CITY OF PORTLAND

Permit Number: 100041

This is to certify that 574 ASSOCIATES LLC /Anthony Allen
has permission to Change of use from Retail to Restaurant combining retail space w/ existing Restaurant "Otto's" w/interior renovat
AT 576 CONGRESS ST CBL 037 G007001

Past Use: Retail under permit #030660	Proposed Use: Restaurant - Change of use from Retail to Restaurant combining retail space w/ existing Restaurant "Otto's" w/interior renovations	Permit Fee: \$175.00	Cost of Work: \$8,000.00	CEO District: 1	
Proposed Project Description: Change of use from Retail to Restaurant combining retail space w/ existing Restaurant "Otto's" w/interior renovations		FIRE DEPT: <input checked="" type="checkbox"/> Approved <input type="checkbox"/> Denied <i>*See Conditions</i>	INSPECTION: Use Group: B L500L Type: IBL-2003 Signature: <i>JMB 2/1/10</i>		
		PEDESTRIAN ACTIVITIES DISTRICT (P.A.D.) Action: <input type="checkbox"/> Approved <input type="checkbox"/> Approved w/Conditions <input type="checkbox"/> Denied Signature: _____ Date: _____

PROPOSED LAYOUT

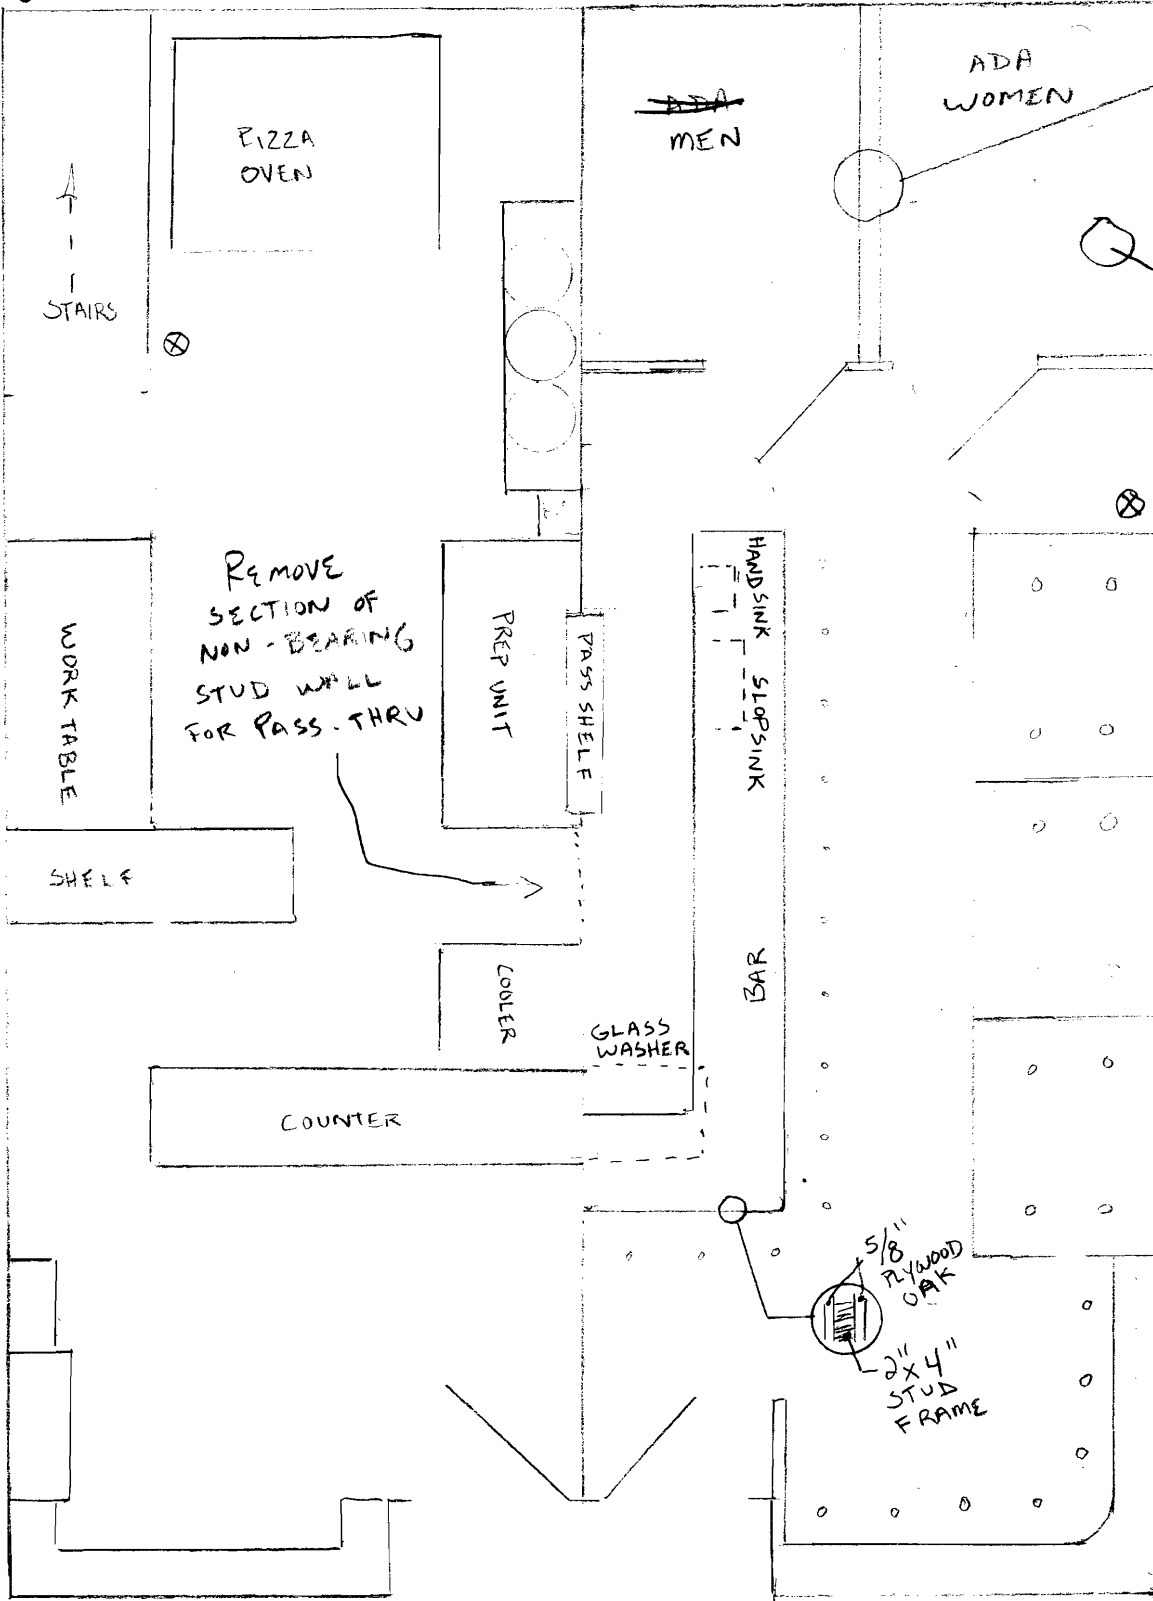
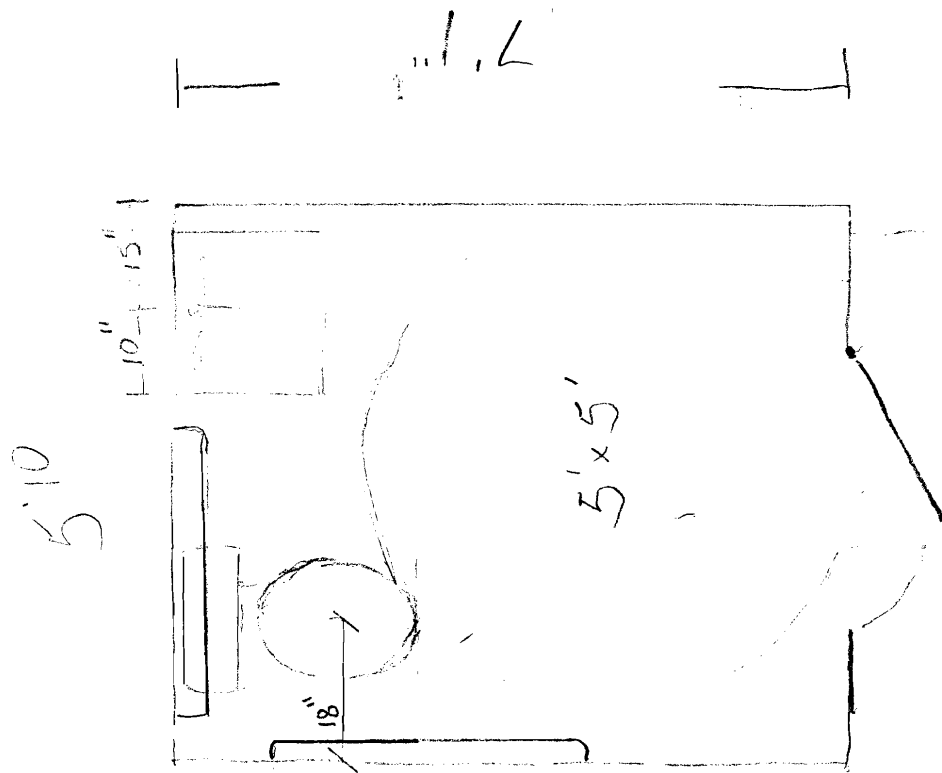
- 1) BASEMENT IS RESTRICTED TO STORAGE ONLY DUE TO ONLY ONE MEANS OF EGRESS.
- 2) Approval of City license is subject to health inspections per the Food Code.
- 3) New cafe, restaurant, lounge, bar or retail establishment where food or drink is sold and/or prepared shall meet the requirements of the City and State Food Codes
- 4) Equipment must be installed in compliance per the manufacturer's specifications
- 5) Permit approved based on the plans submitted and reviewed w/owner/contractor, with additional information as agreed on and as noted on plans.
- 6) Separate permits are required for any electrical, plumbing, sprinkler, fire alarm or HVAC or exhaust systems. Separate plans may need to be submitted for approval as a part of this process.

2/1/2010-jmb: Spoke with Anthony, verified the basement will be for storage only and now only the right side bathroom will be ADA as the dimensions don't allow 2. Per plumbing code can be unisex if under 1500 sf.
